**Consultation Response from KC,  
Trees**

**2024/92647 Land at Occupation Lane, off Birkby Road, Huddersfield, HD2 2ES**

**Erection of detached dwelling with detached garage**

**Date Responded: 26/09/2024**

Drawing title
Site Plan as Proposed

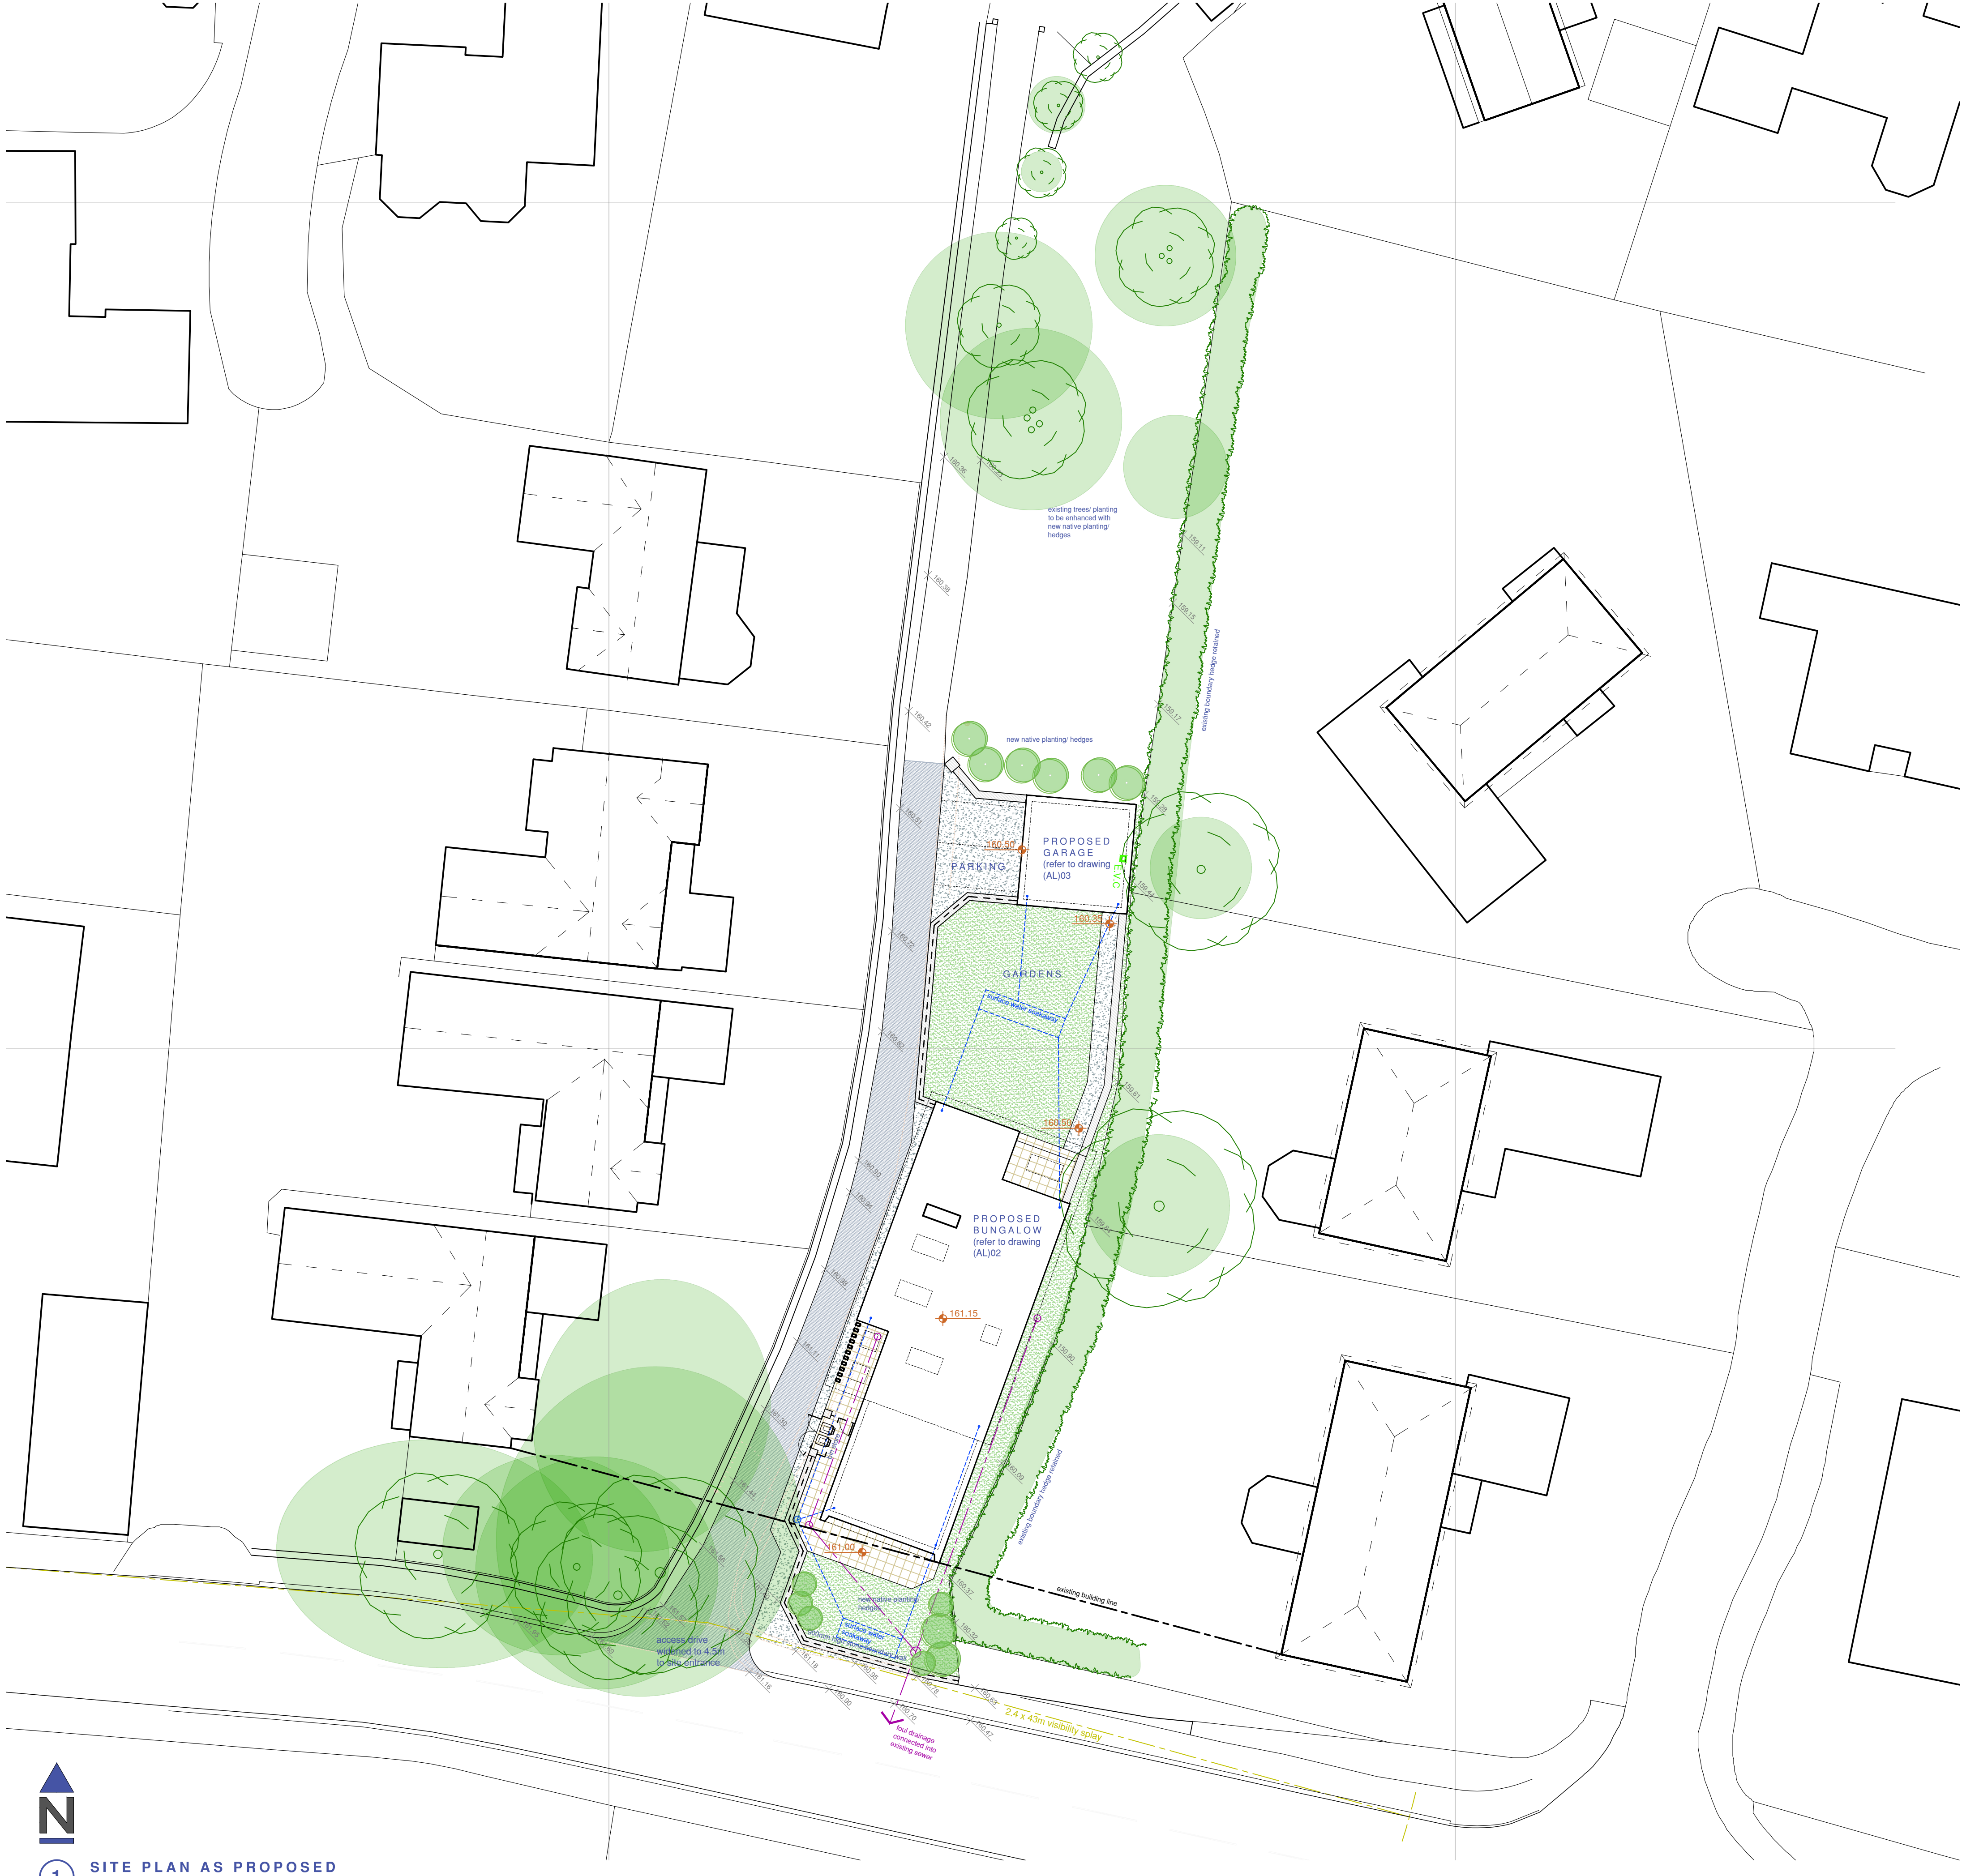
On the whole there is no objection to the development as the existing hardstanding at the entrance will sufficiently protect the TPO'd trees root protection areas and no other trees should be affected within the site.

Care should be taken when working around the unprotected trees on third party land to the east as significant ground disturbance with the RPA's of these trees may have an effect on their future health. No further comments or objections.
